**2 FIGTREE DRIVE
SYDNEY OLYMPIC PARK**

ACCESS REVIEW

Morris Goding Accessibility Consulting

7 August 2015

ADAPTABLE APARTMENTS

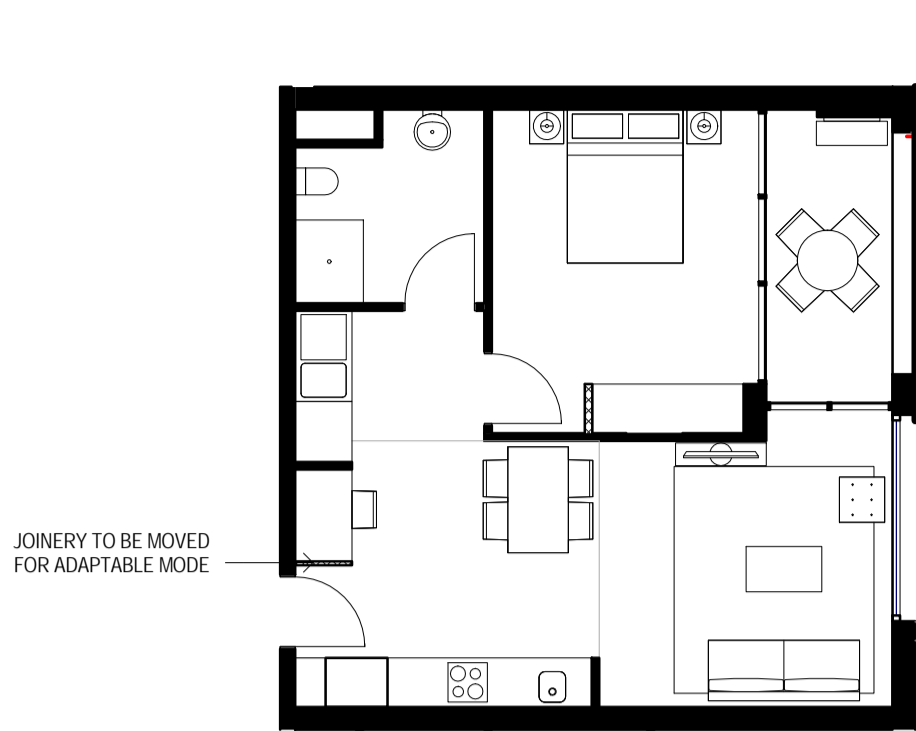
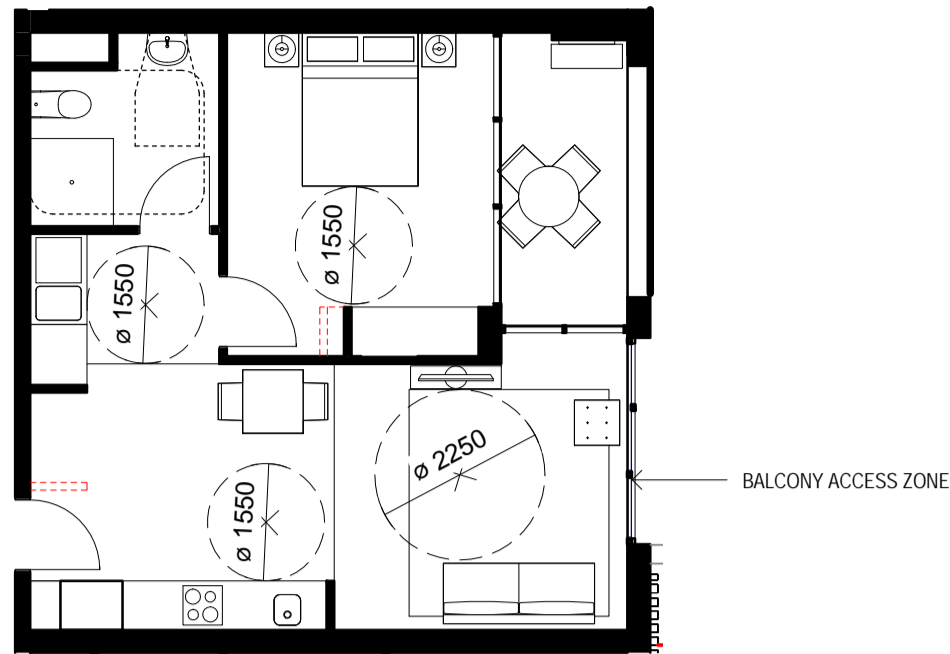
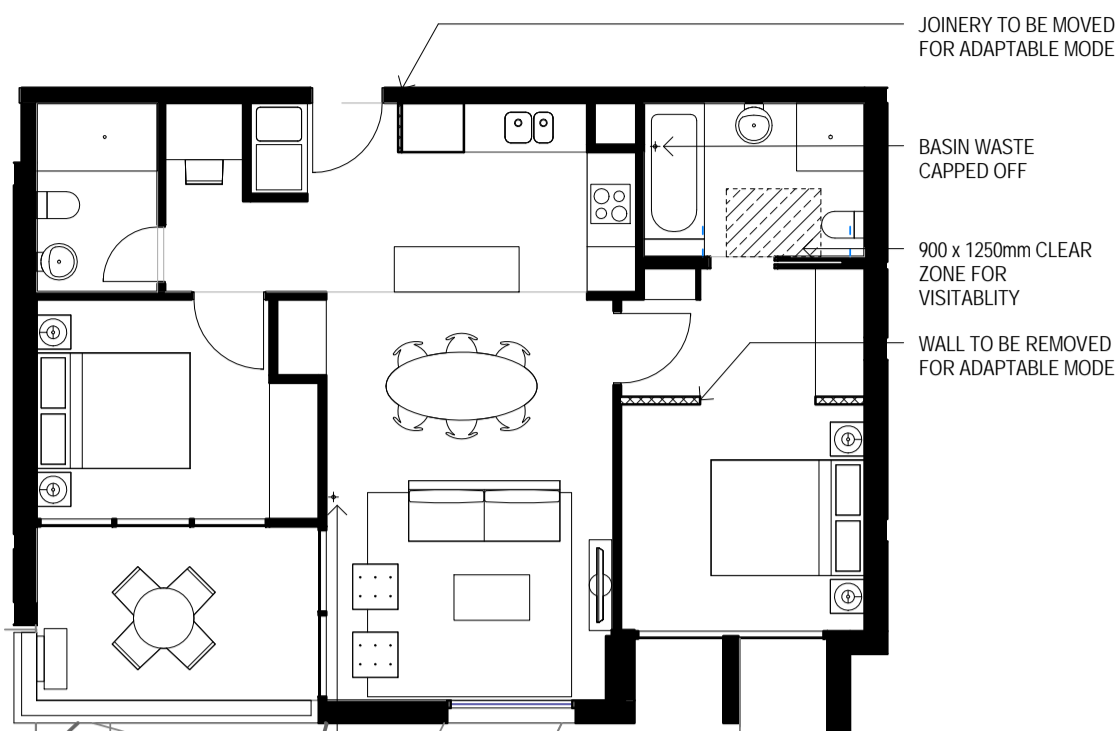
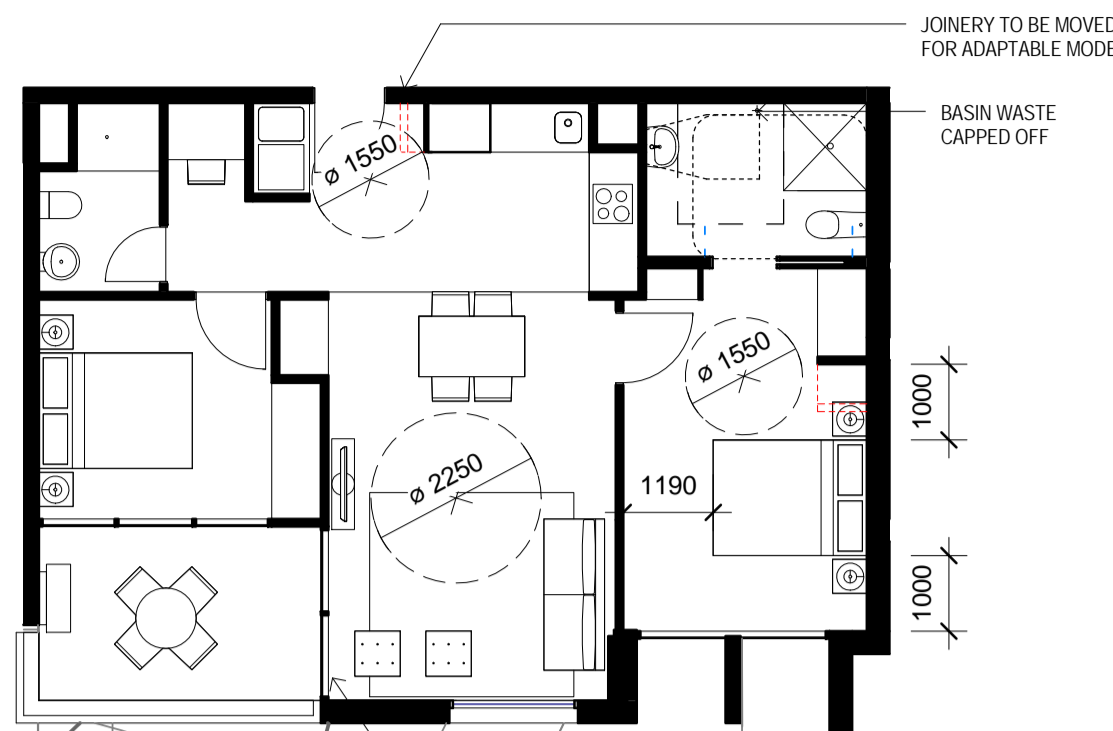
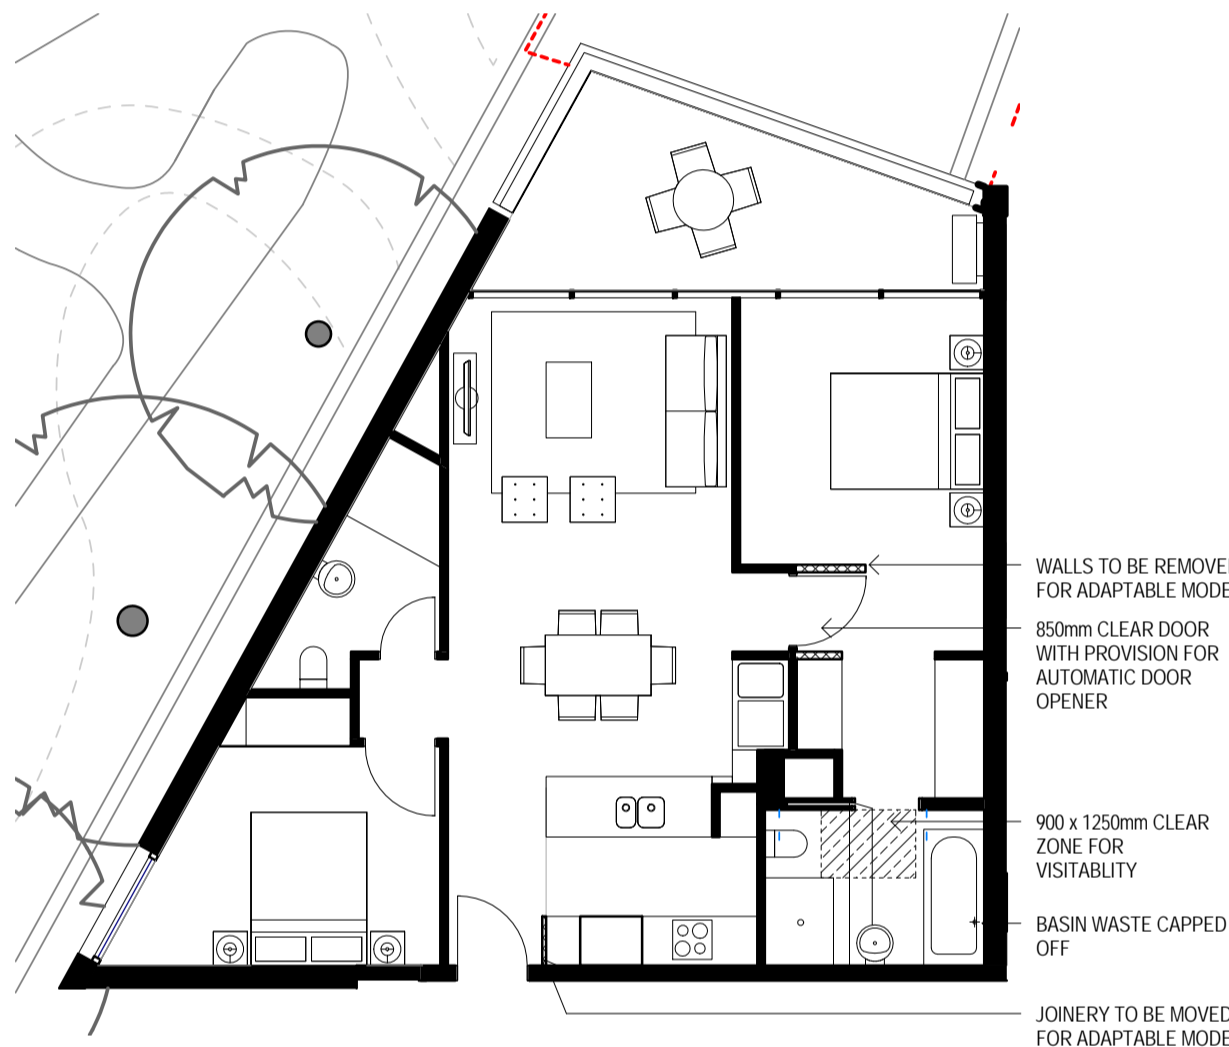
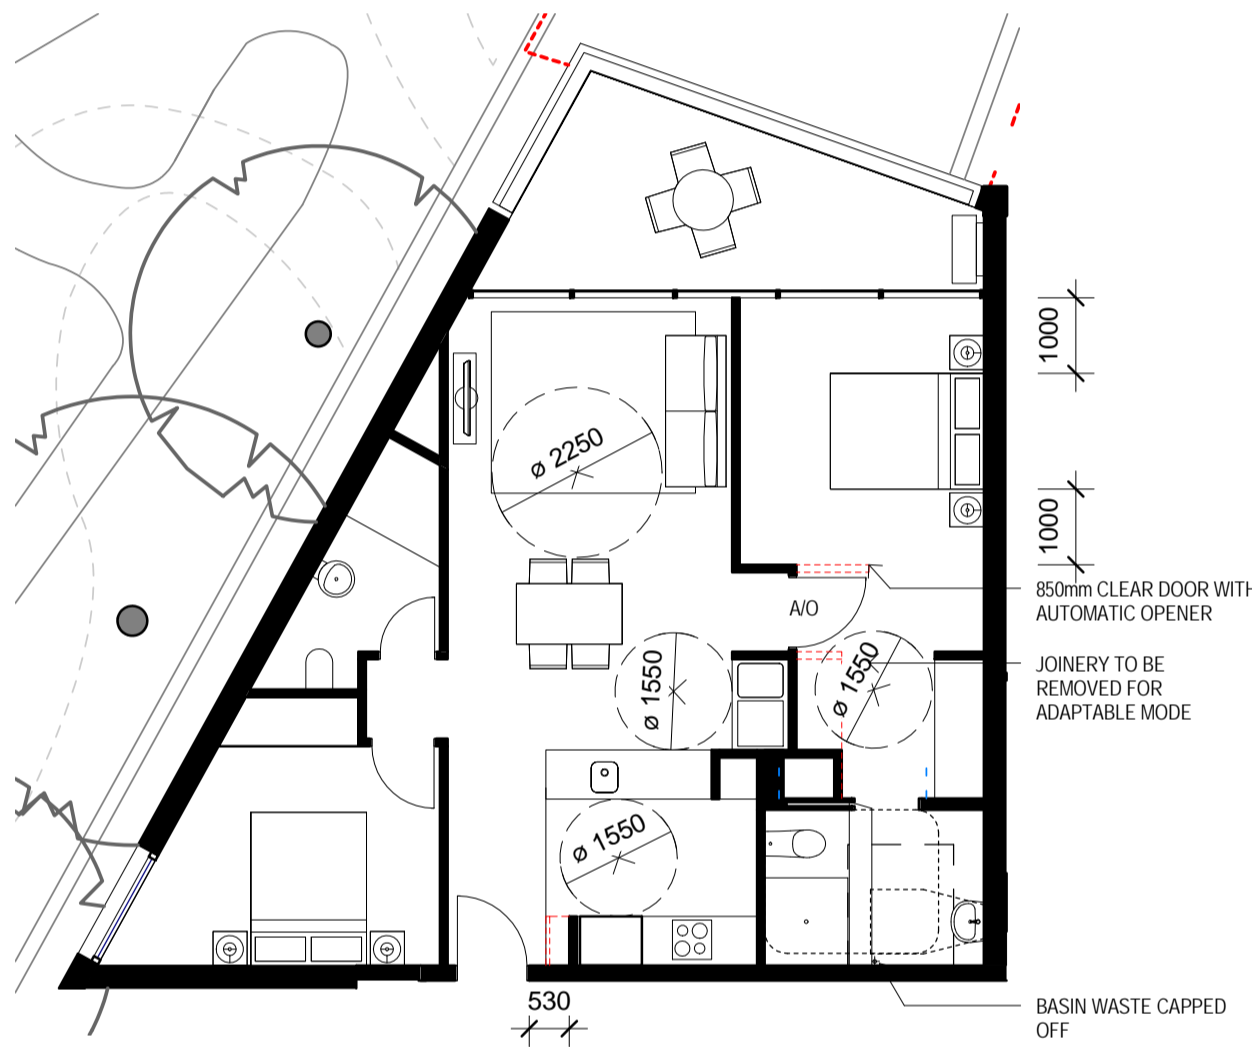
Drawing No: DA-2200-C has been reviewed for the key elements required at pre-adaption stage to satisfy the spatial requirements of AS4299. There are 4 adaptable unit types proposed within the development that include 1 Bed – Type 1, 2 Bed – Type 1, 2 Bed – Type 2, 3 bed- Type 1.

Each adaptable unit type has an 850mm clear width opening hinged unit entry door that can achieve door clearances compliant with AS4299.

There are accessible internal corridors leading to the essential features of the adaptable unit. The internal doors within the adaptable housing unit (as defined in AS4299 clause 1.4.6) have appropriate 850mm clear width opening and can achieve door clearances compliant with AS4299.

The adaptable bedroom has appropriate internal dimensions to satisfy AS4299 circulation requirements.

The adaptable bathroom has suitable internal dimensions to satisfy shower, pan, wash basin circulation area requirements of AS4299. A visitable toilet has provided within the adaptable unit as required by AS4299.

The kitchen can achieve appropriate clearance of 1550mm as required under AS4299 and can achieve work bench spaces adjacent to refrigerator, cook top, oven and sink under AS4299.

In addition to the currently documented spatial provisions on Drawing No: DA-2200-C, the following recommendations are applicable to all adaptable unit types.

- (i) Provide a slip-resistant floor surface (AS4586/HB198) in kitchen, laundry and adaptable bathroom at pre-adaption stage as required by AS4299 clause 4.5.4.

- (iii) Where sanitary fixtures are not located to suit AS1428.1 from outset, suitable provision i.e. extra capped off plumbing supplies/waste to be provided for bathroom fixtures/fittings, compliant with AS1428.1 for ease of adaption.

- (vi) Within adaptable bathroom; wall-strengthening around pan, shower and bath (for grab rails and shower seat) and waterproofing of walls to be provided at pre-adaptation stage in accordance with AS4299, clause 4.4.4h.
